GADRA
108 Homefarm Road
Drumcondra
Dublin 9

Re: Railway (Metrolink - Estuary to Charlemont via Dublin Airport) Order [2022]
Metrolink. Estuary through Swords, Dublin Airport, Ballymun, Glasnevin and City Centre to
Charlemont, Co. Dublin

MetroLink Submission Railway Order (RO) 2022

ALBERT COLLEGE PARK INTERVENTION SHAFT. PLAN
SCALE 1:400

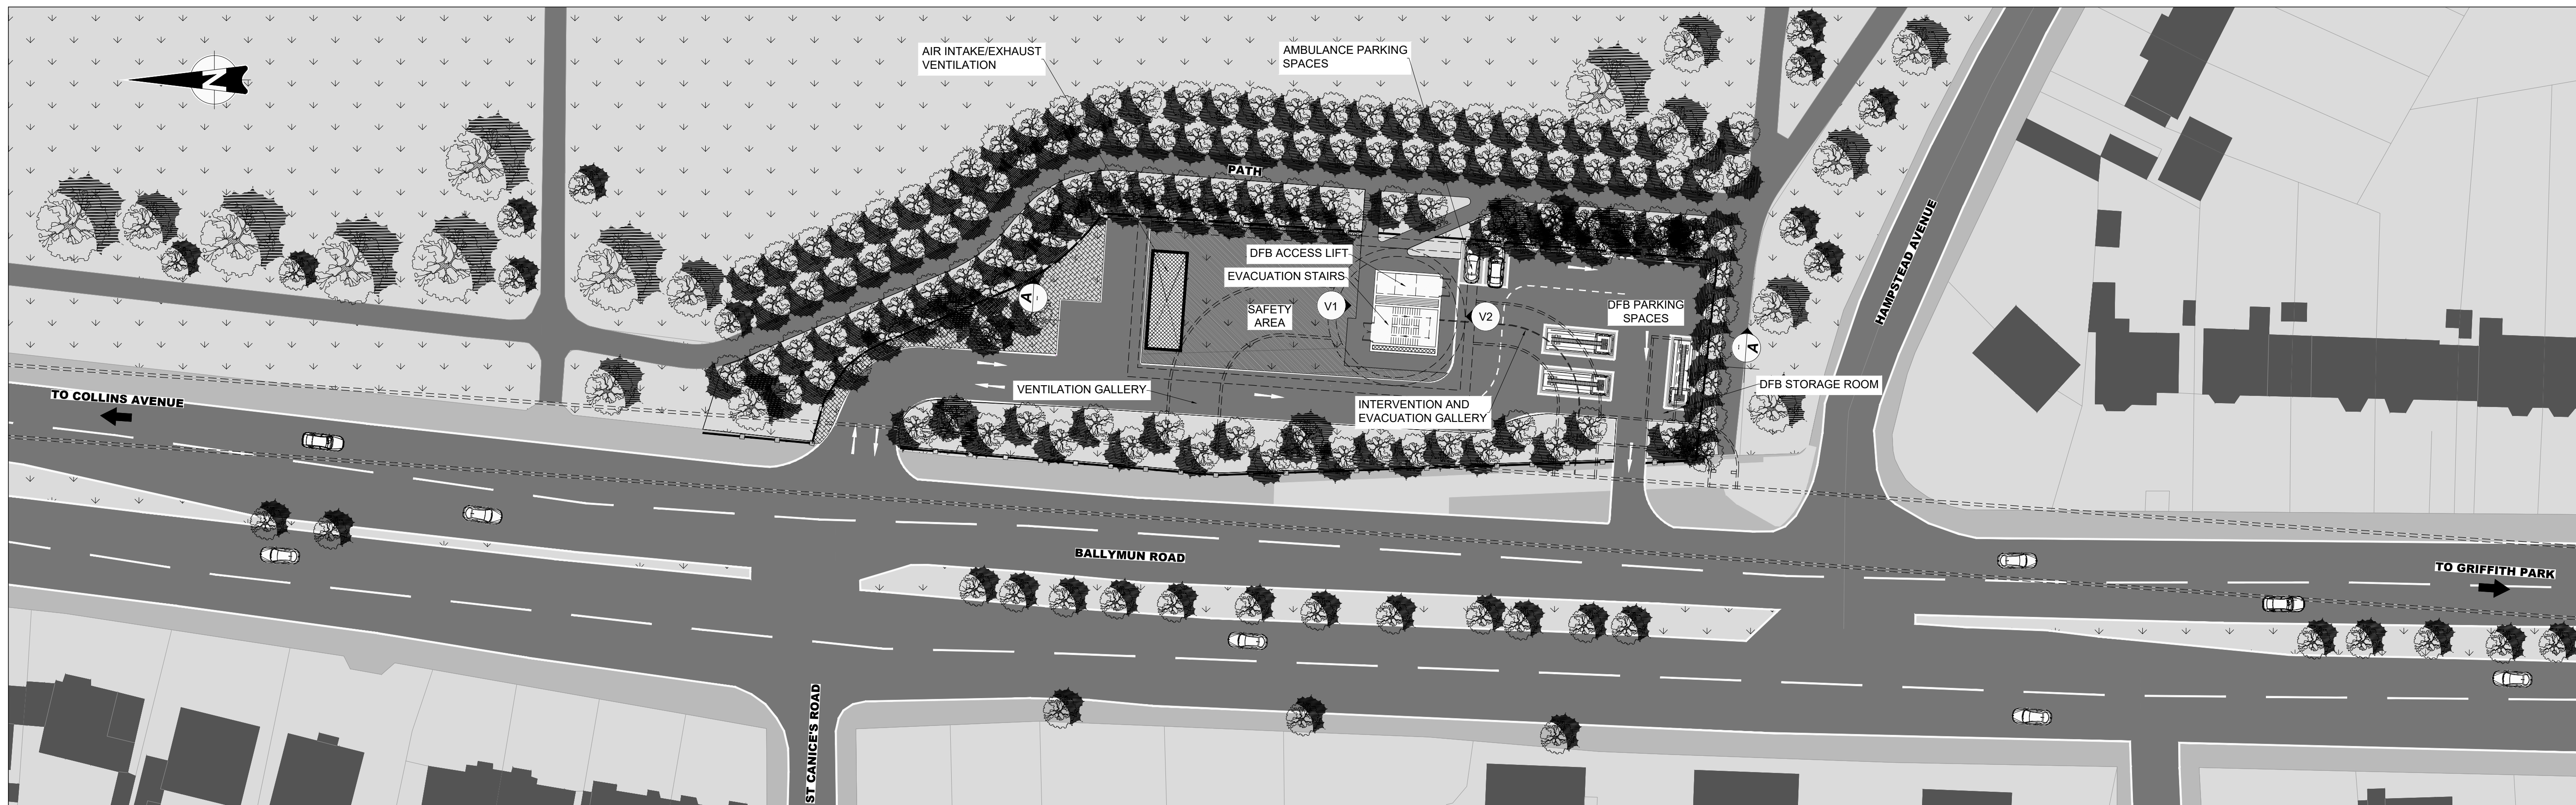
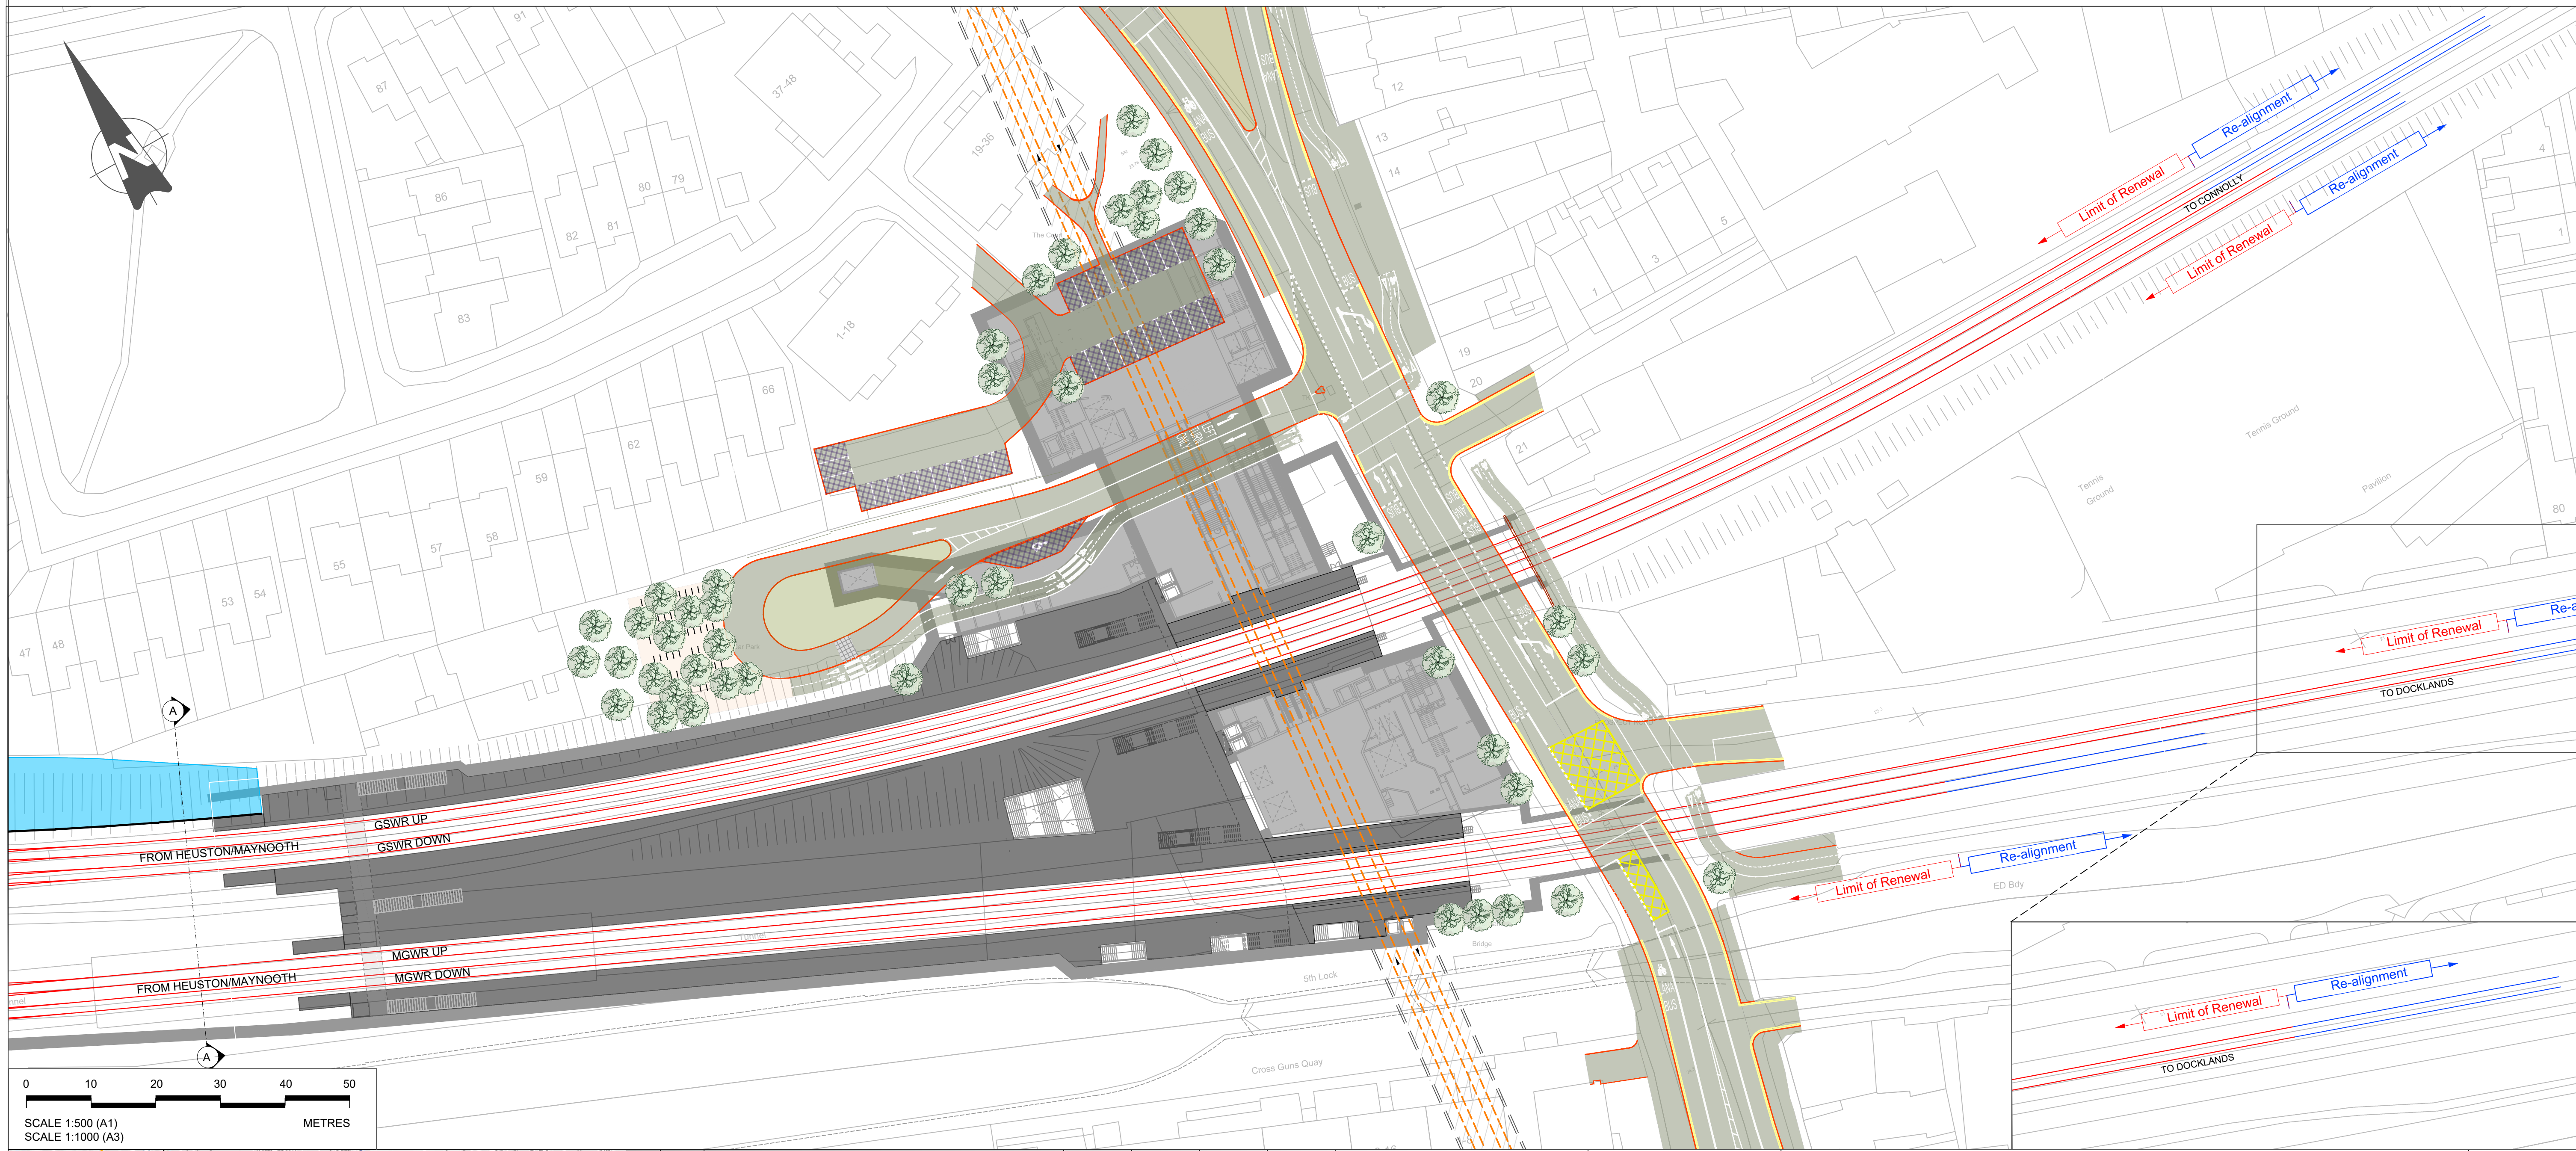
GADRA would, at the outset, like to state that we object to the positioning of an Intervention Shaft in a public park, which will permanently remove an area of public park from public use.

The Intervention Shaft has a large above ground permanent footprint- Section 4.17.5 states that Albert College Park is a large area of Non-residential land to construct the intervention shaft and house the permanent facilities. Albert College Park is a public park that is highly valued and irreplaceable in the area. It is zoned as Z9 and should never be used as a car park or maintenance facility. Following discussion with our Independent Experts and much extensive research we are unable to find any other Metro system that has positioned a shaft and carpark/ emergency vehicle parking into a public park, which was confirmed by the Independent Expert.

The moving of the station from Na Fianna to Homefarm pitch has caused the need for an intervention shaft and, despite GADRA asking as early as 2018 about any requirement for a shaft within our area, and constantly requesting information on this shaft, TII did not produce any information in relation to the shaft except for one sentence in the Preferred Route consultation. This shaft is a material permanent above ground structure, yet the public were not given any information on this shaft during the consultation phase and were not given any alternative site rather than in a public park. Indeed, the only consultation that occurred on the shaft was in relation to design, not position.

GADRA would also request that the Inspector look at the Z9 zoning, which the area planned for shaft is currently zoned as. While such zoning does allow for green transport, GADRA do not believe that a ventilation shaft meets these criteria. A station within the park on Z9 lands however does fulfil the zoning requirements. Since the emergence of the Intervention Shaft proposal, GADRA have been asking that the alternate option of station at this location be considered, which would have a smaller footprint in the park in the longer term and would allow the public access the benefits of the station, which is after all positioned in a public park. An underground station, while disruptive during the construction phase, would in our opinion, have less significant impact once operational and have benefits for the public and would fulfil the zoning requirements. This station in the park should be constructed as a dual entrance station with a northerly entrance 70 meters south of DCU gates and a southerly entrance 100 meters north of Hampstead Avenue
